Our ref: RA/2025/148811/01-L01
Your ref: 2025/92327

Date: 09 October 2025

**ERECTION OF 4 DWELLINGS (WITHIN A CONSERVATION AREA) – LAND
ADJACENT TO, 185, WOODHEAD ROAD, HOLMBRIDGE, HD9 2NW**

Proposed River Level Plan - 1:200

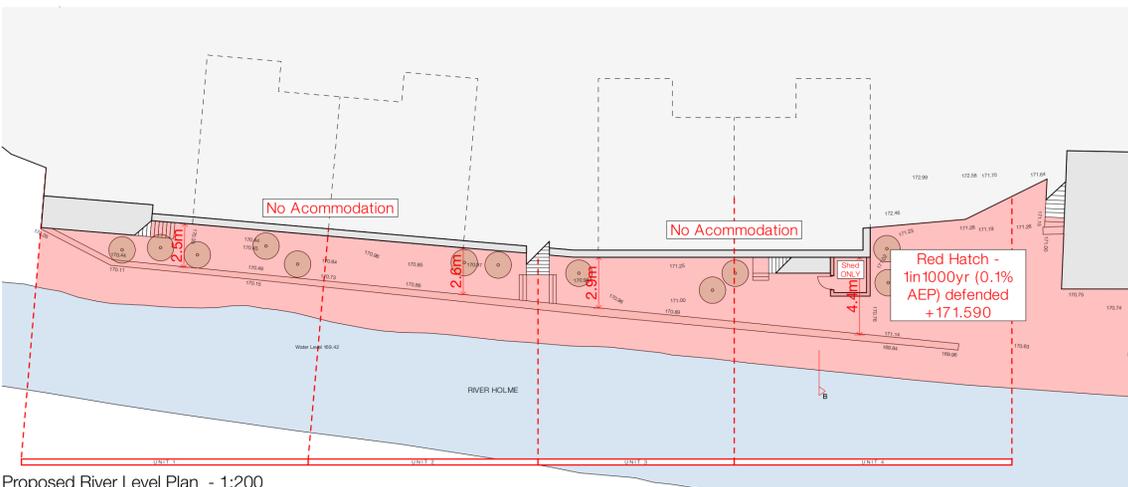
The proposed development would restrict maintenance and emergency access to the watercourse. The permanent retention of a continuous unobstructed area is an essential requirement for future maintenance and/or improvement works.

The applicant should arrange the site layout so that there is an unobstructed easement of 6 metres as measured from the top of the bank.
